Croft Medical Centre – Response to Highways comments in relation to the proposed replacement Medical Centre (Ref: EG/57/16/PL)

1. This note sets out the comments made by West Sussex County Council (WSCC) in relation to the proposals to construct a replacement Medical Centre on the plot of land to the west of the existing facility in Eastergate.

SUBJECT: EG/57/16/PL

DESCRIPTION: Medical centre with pharmacy retail unit & other ancillary uses together with access onto Barnham Road & associated car parking. This application is a Departure from the Development Plan.

SITE PLAN SCALE 1:200

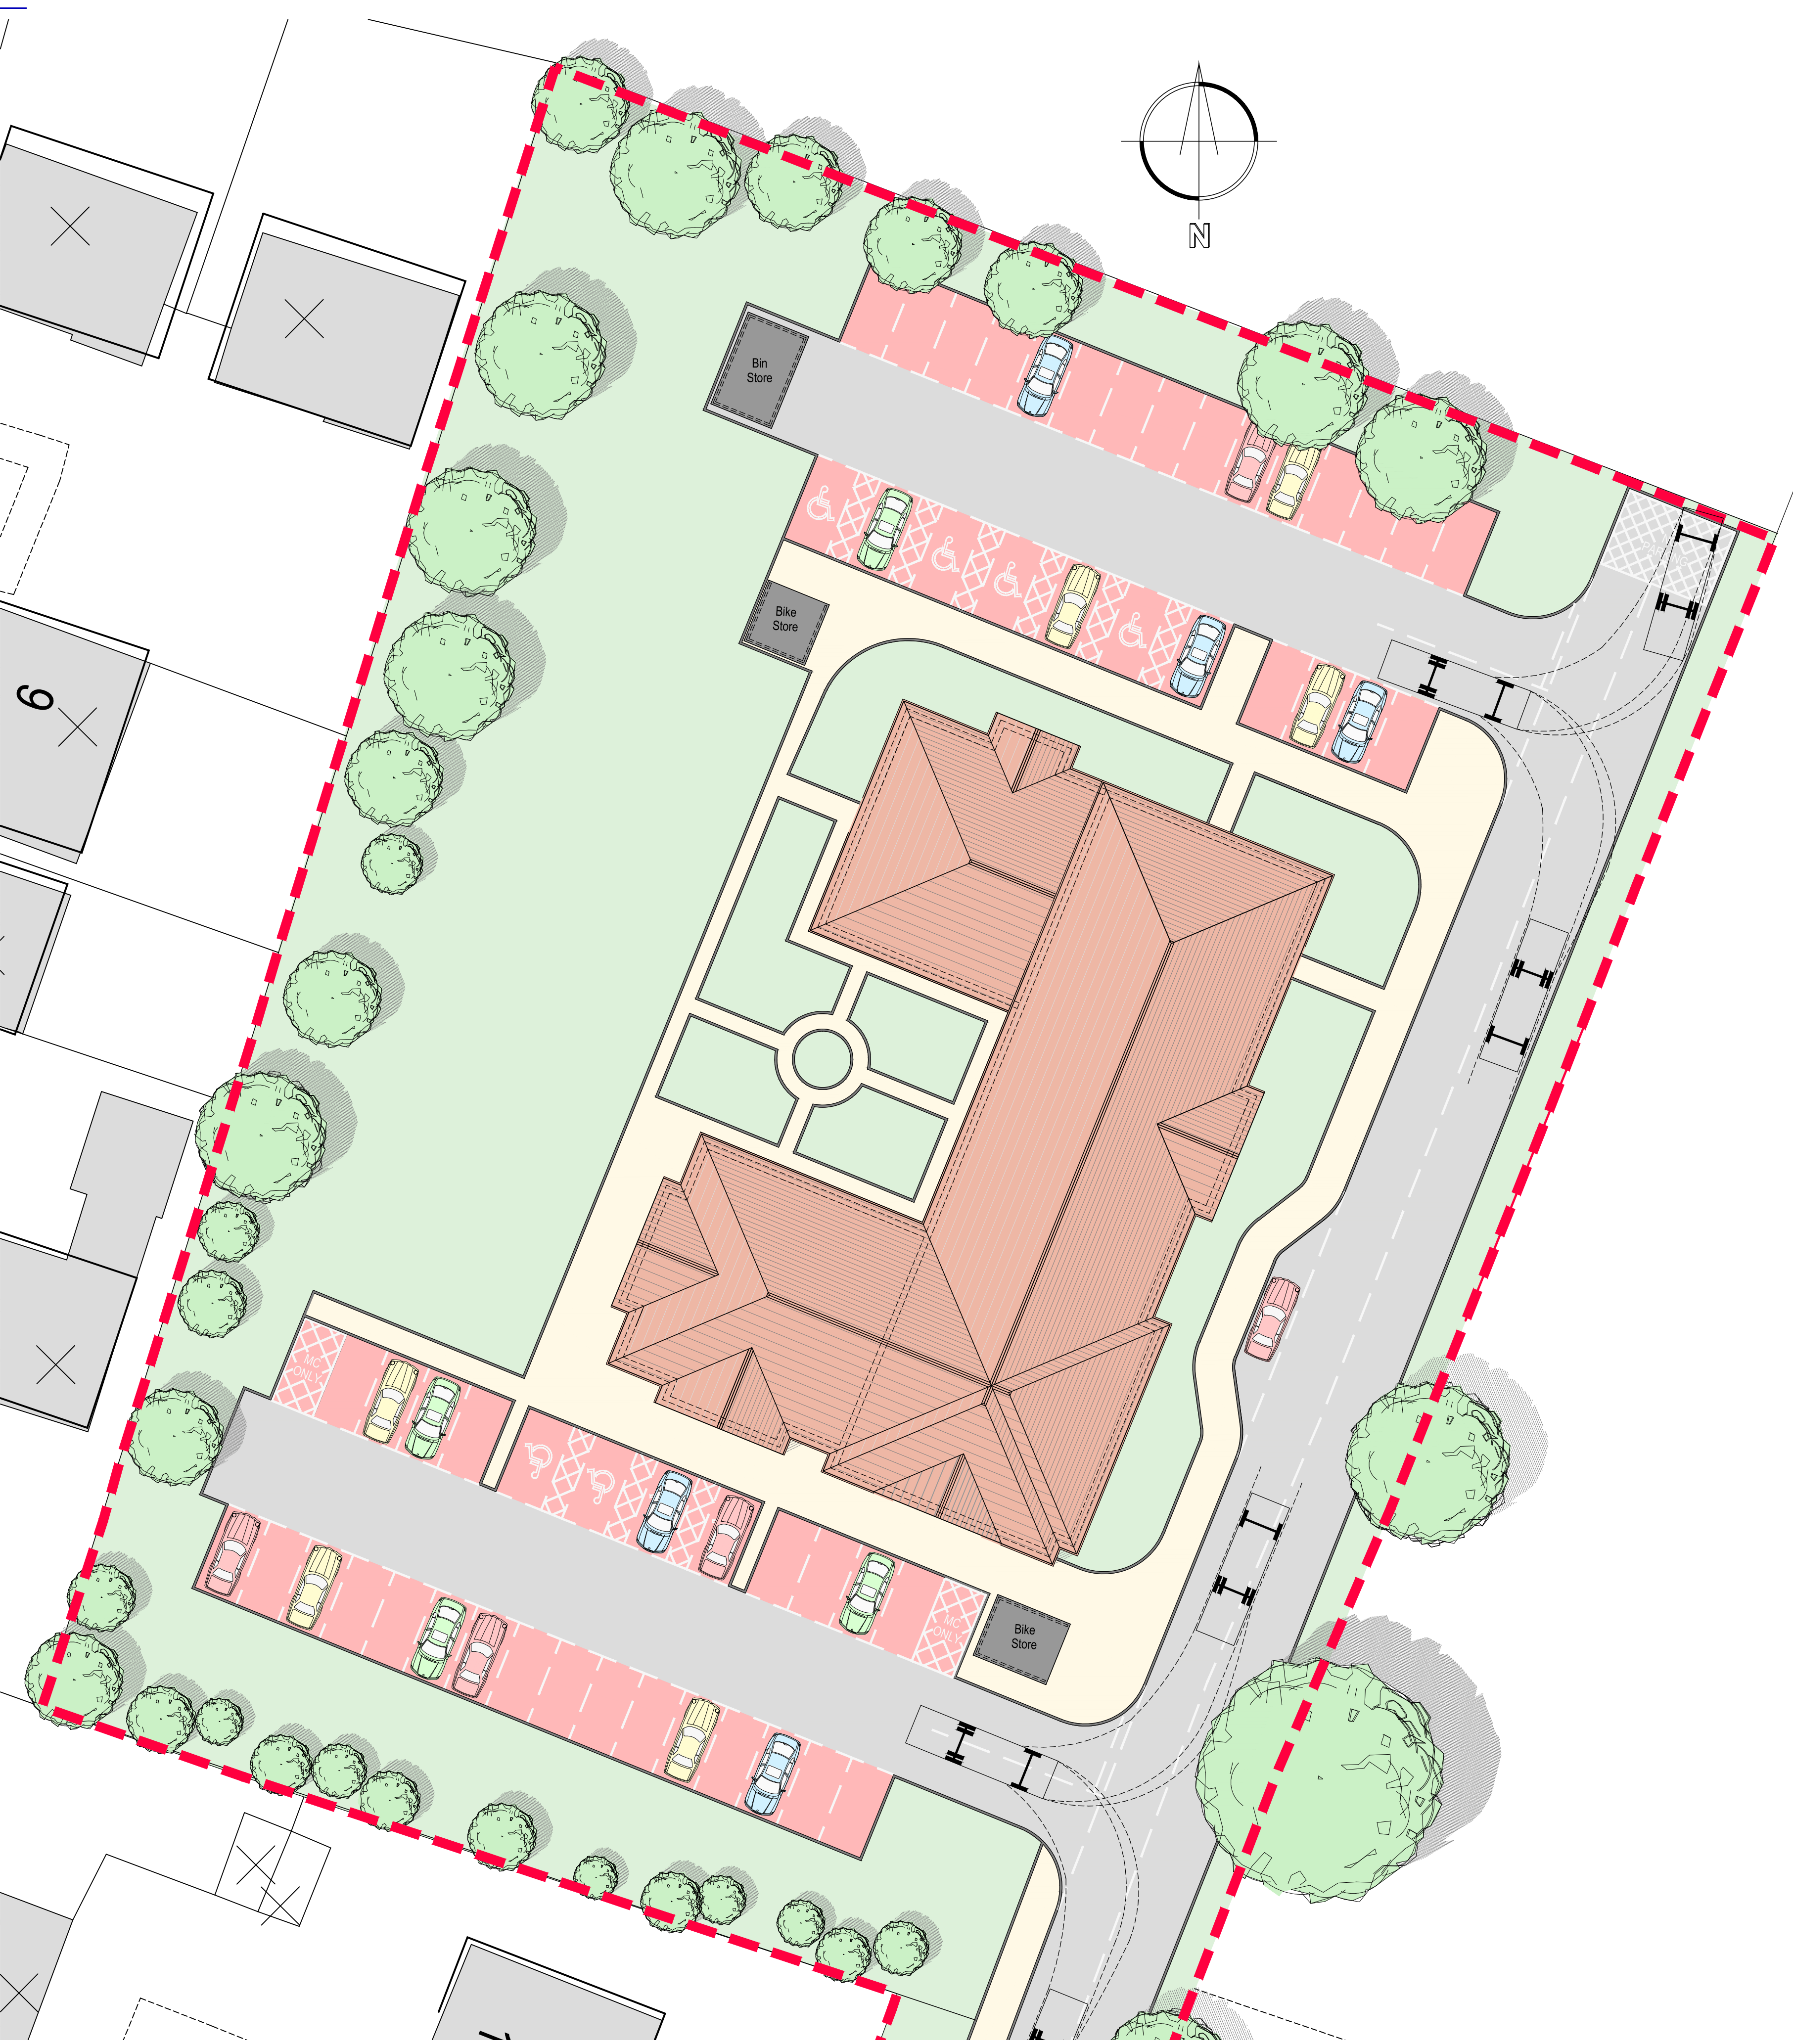
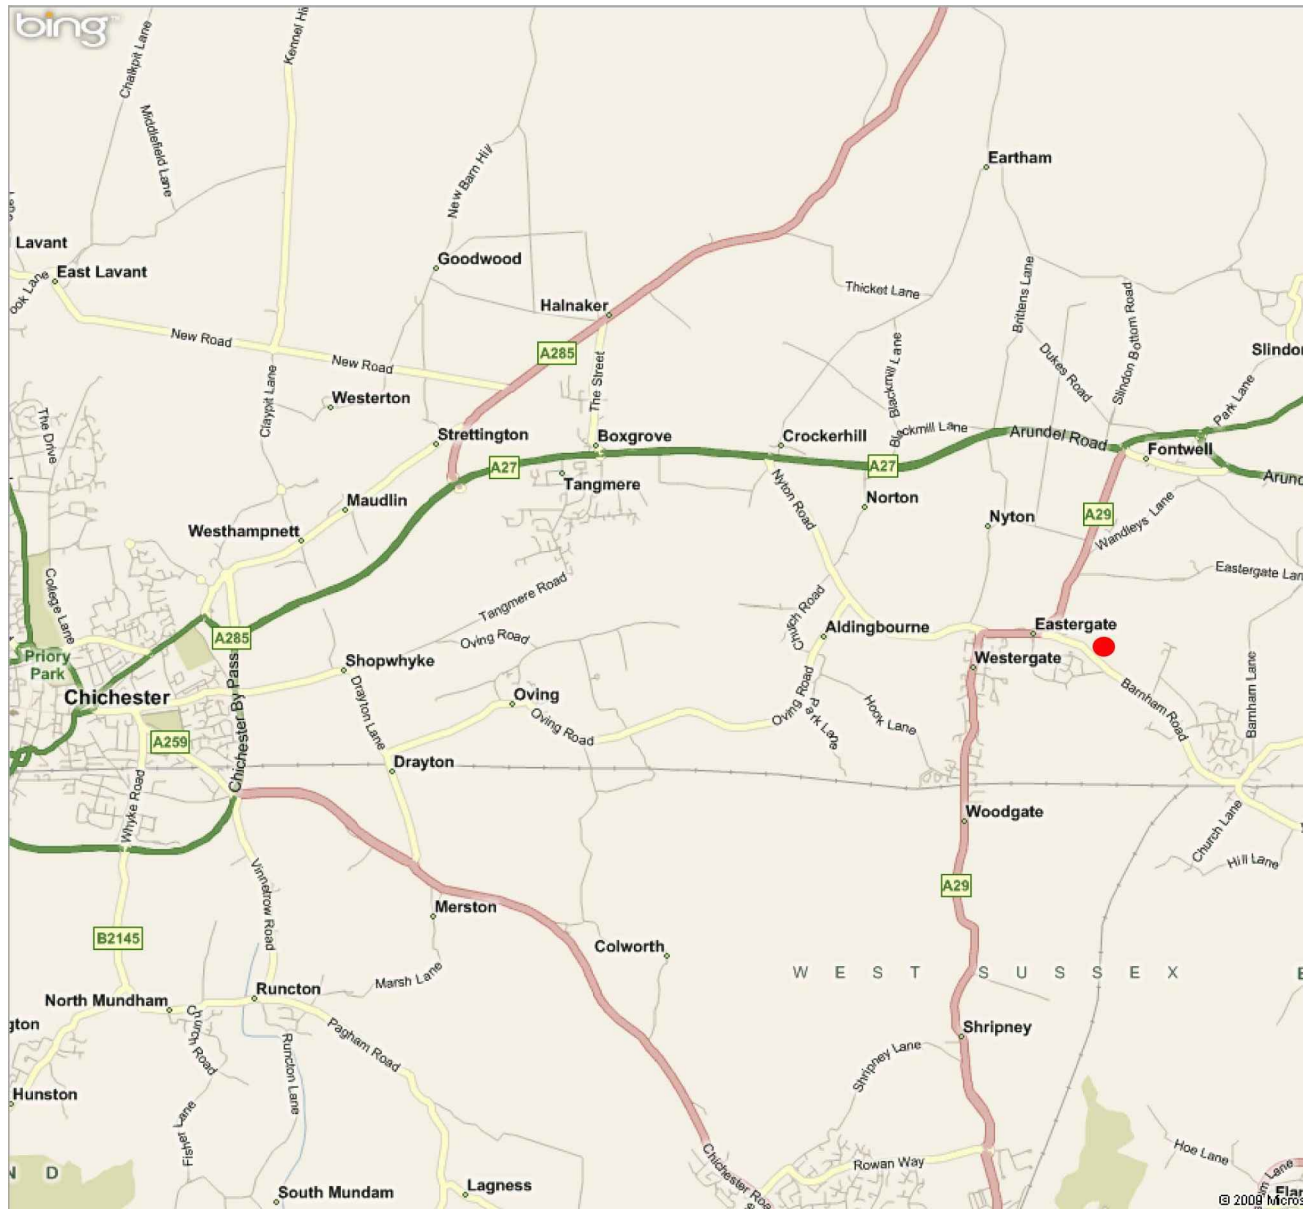
It is noted that section 5.07 of the Design & Access Statement indicates that the 28 parking spaces to the south of the building will be for visitors to the surgery, whilst the 26 spaces (including 7 disabled spaces) to the north of the building will be mostly for staff. This will also serve as overspill for the front car park should the practice experience higher than anticipated levels of visitors. Given that the existing surgery provides 28 spaces for patients and a separate staff car park with 15 spaces, the LHA are concerned that the combined number of parking space for visitors and staff as proposed will be insufficient given the increase in size of the building and consulting rooms. There would be more people visiting the site and more staff to operate the surgery. The LHA would advise that given the known access and parking issues of the current surgery the applicant submits a revised parking strategy, taking on board the standards referred to under the WSCC Parking Standards.

A dedicated turning head has been shown at the end of the access road. This appears small and there doesn't appear to be any barriers to stop parking occurring on the site access road in this location to make sure this area is kept clear for large vehicles to turn at all times.

It is also not clear what type of vehicle has been used on the tracking diagrams. The LHA would request that revised tracking is provided to demonstrate that a large refuse truck could turn on site to exit onto the highway in forward gear.

Road Safety Audit (Stage 1) There has been no audit submitted with this application. A development of this size would require a Stage 1 Road Safety Audit in line with the WSCC Safety Audit Adopted Policy.	A copy of the Stage 1 Road Safety Audit and the Designers Response is included at Annex C.
Parking There are known parking problems that have resulted from the use of the existing surgery at peak times. It is understood this was a driving factor behind the provision of the additional 15 spaces for staff. The WSCC Parking Standards for medical surgeries are detailed and are based on the number of practitioners, the number of consulting rooms, and admin/office space. The proposed provision of 56 spaces falls short given the requirements of the WSCC Parking Standards. It is noted that section 5.07 of the Design & Access Statement indicates that the 28 parking spaces to the south of the building will be for visitors to the surgery, whilst the 26 spaces (including 7 disabled spaces) to the north of the building will be mostly for staff. This will also serve as overspill for the front car park should the practice experience higher than anticipated levels of visitors. Given that the existing surgery provides 28 spaces for patients and a separate staff car park with 15 spaces, the LHA are concerned that the combined number of parking space for visitors and staff as proposed will be insufficient given the increase in size of the building and consulting rooms. There would be more people visiting the site and more staff to operate the surgery. The LHA would advise that given the known access and parking issues of the current surgery the applicant submits a revised parking strategy, taking on board the standards referred to under the WSCC Parking Standards. It is understood that there would be some essential car users, for which car parking should be provided. There is the opportunity to encourage less car dependency for those staff that are not	The layout has been amended following discussions with the council to increase the number of parking spaces for cars to 60 as per the plan in Annex D.
